TOWN AND COUNTRY PLANNING (GENERAL PERMITTED DEVELOPMENT) ORDER 2015 PART 6
PRIOR NOTIFICATION OF AGRICULTURAL AND FORESTRY BUILDINGS AND ROADS

Proposal: Prior notification for a proposed earth banked slurry lagoon to store cattle slurry to be utilised on the farm, under Part 6 Schedule 2 of the GDPO.

Location: Foulds House Farm Sabden Road Simonstone BB12 9AD

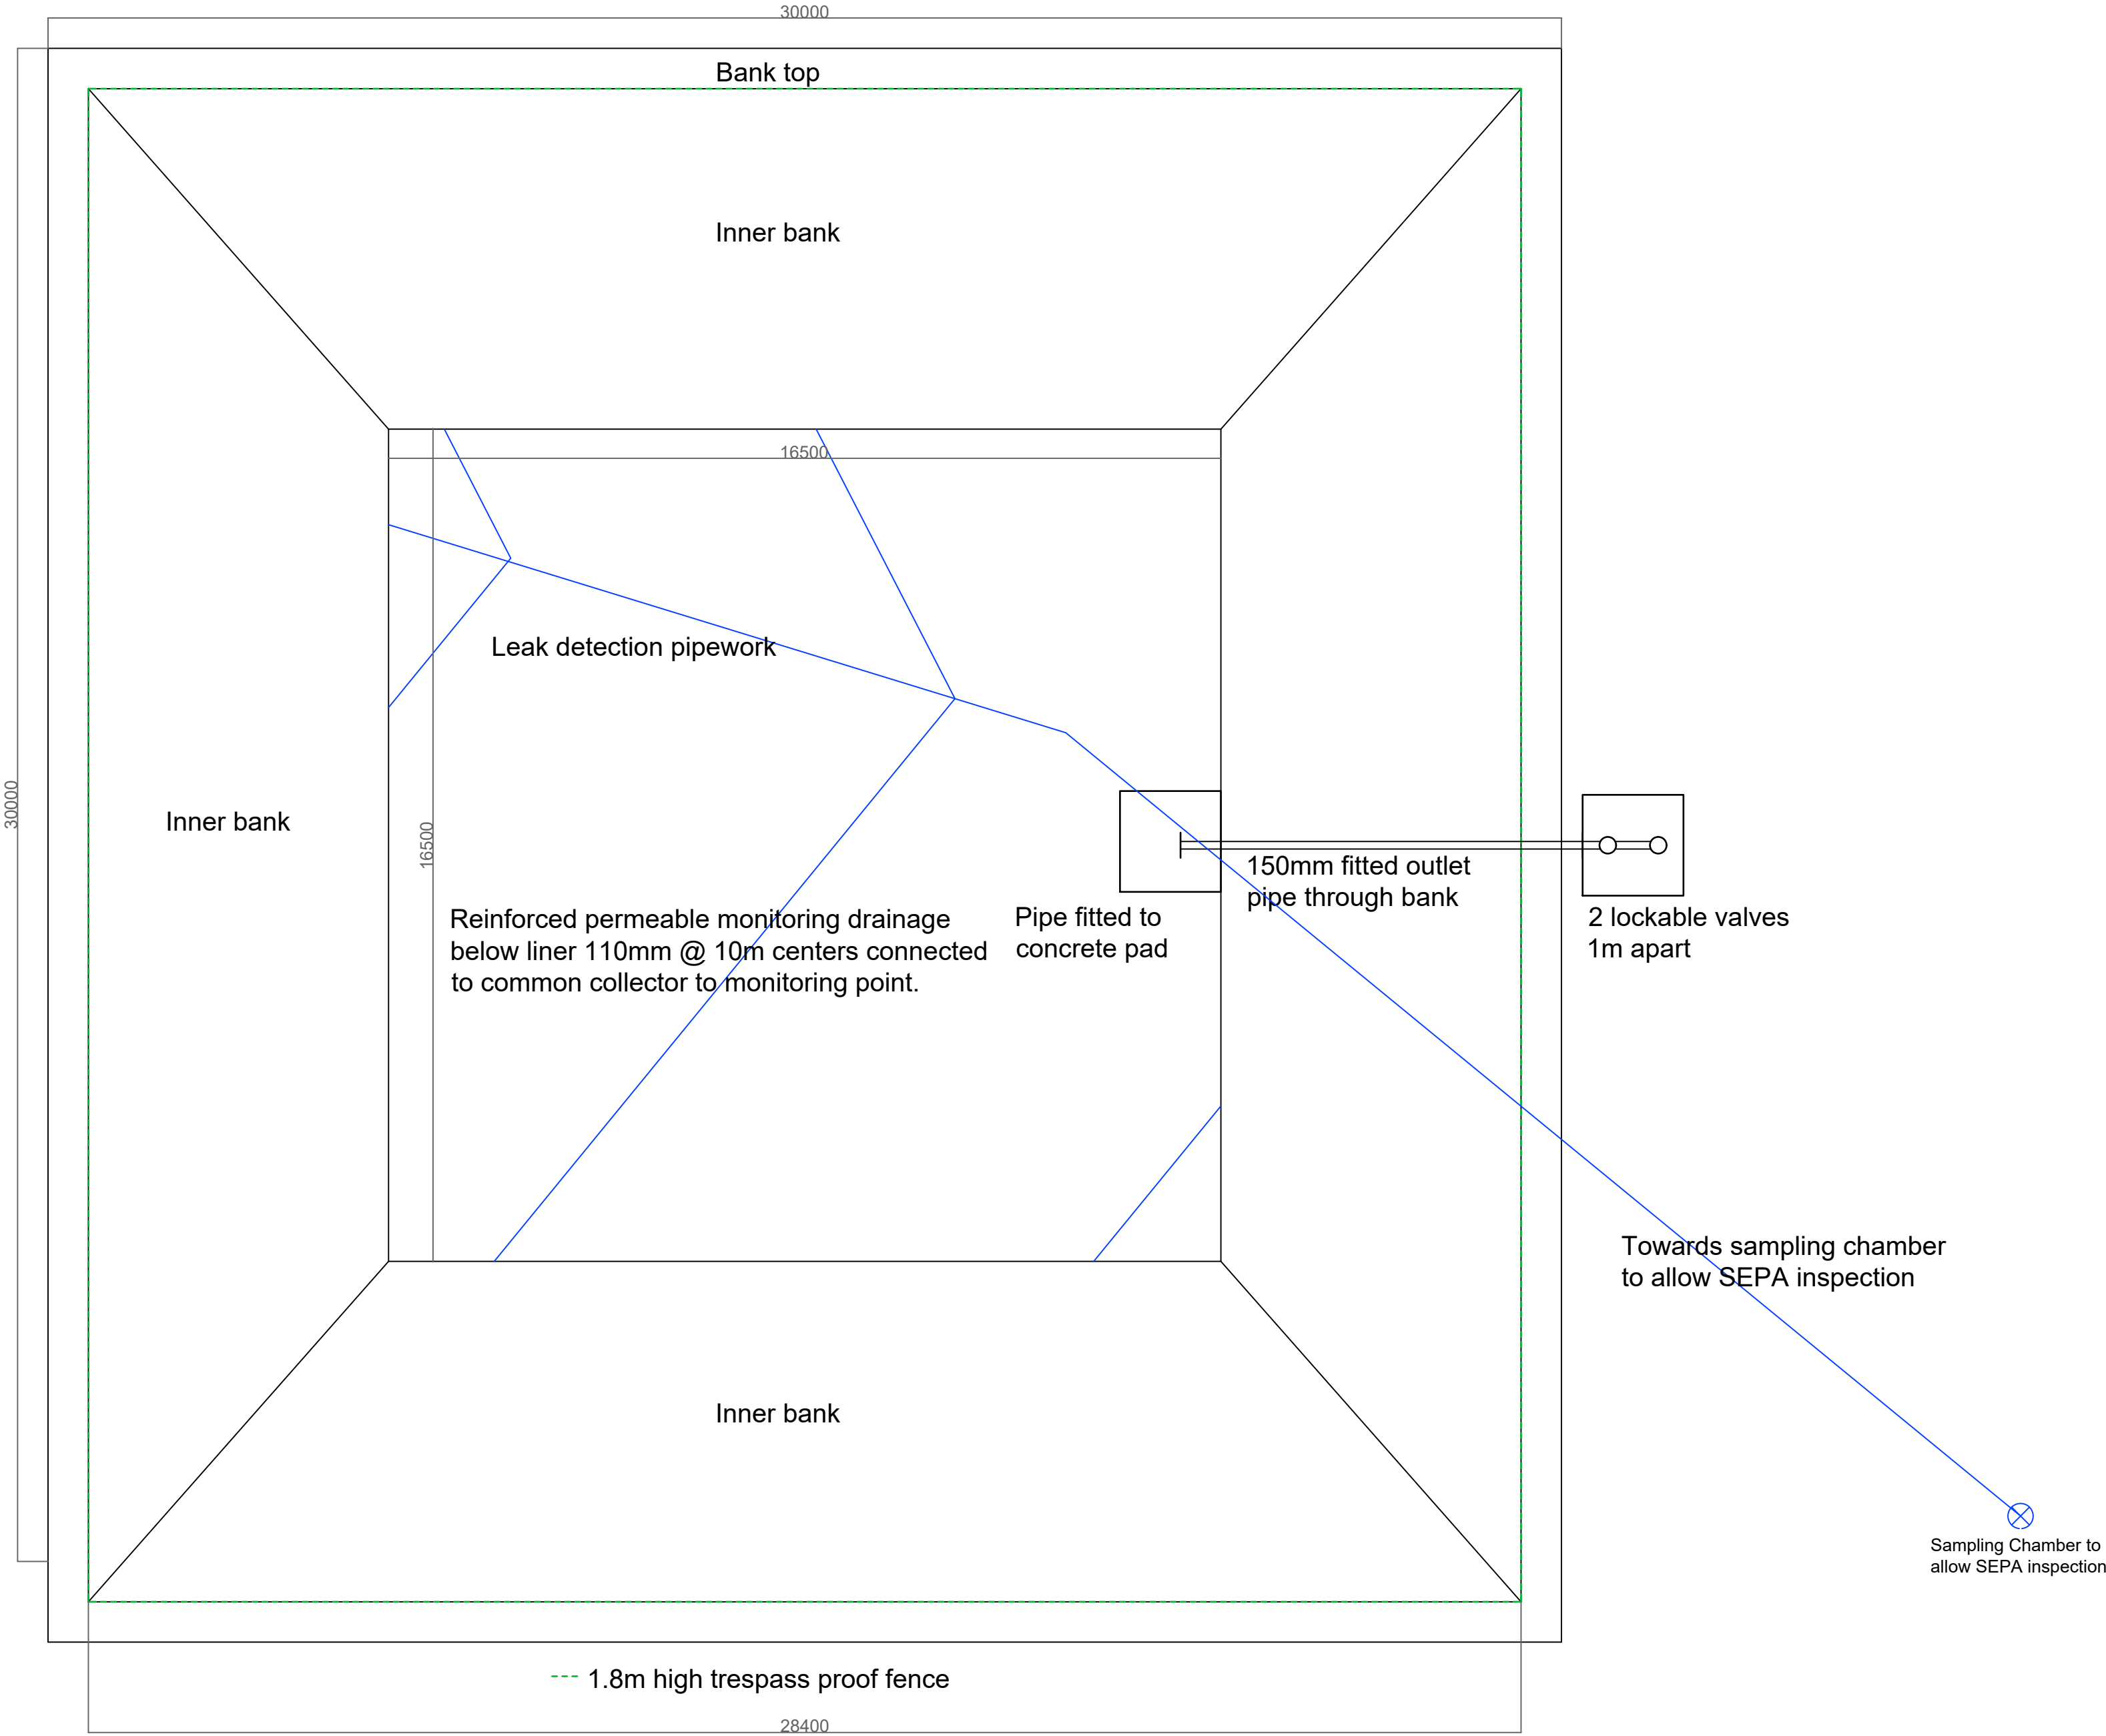
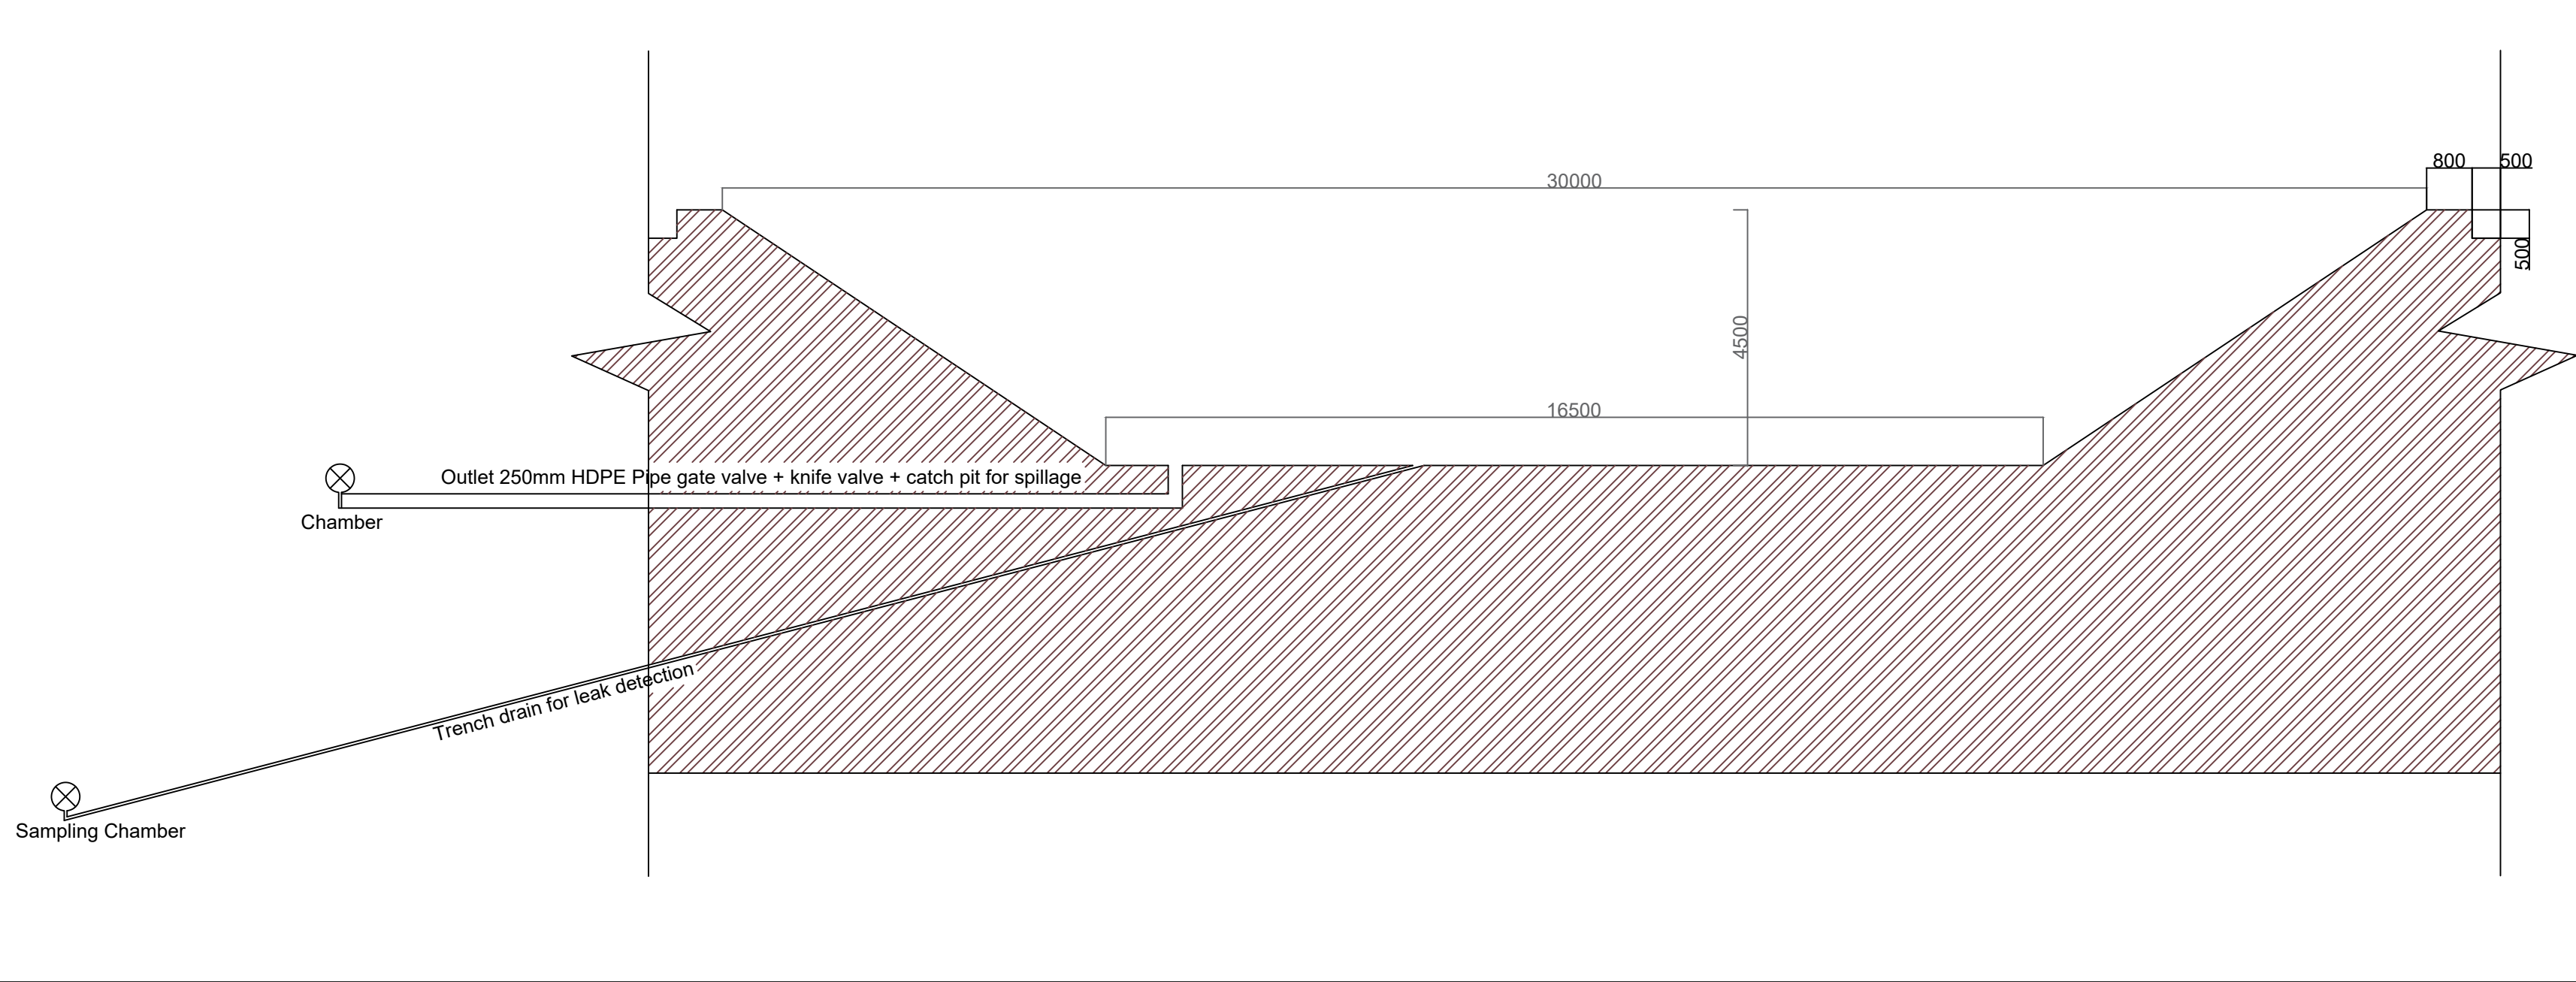
- 1 The proposal fails to satisfy criteria (i) as the proposed building is for the purposes of storing slurry and is within 400m of several residential dwellings.

- 2 The proposed siting would result in an isolated development within an undeveloped land parcel away from the main farmstead without sufficient justification. Similarly, the proposed design by virtue of the perimeter fence, at 1.8m high, would appear overly domestic and incongruous in its surrounds which would increase the visual prominence of the development. As such, the siting and design would be harmful to the character and openness of the open countryside.
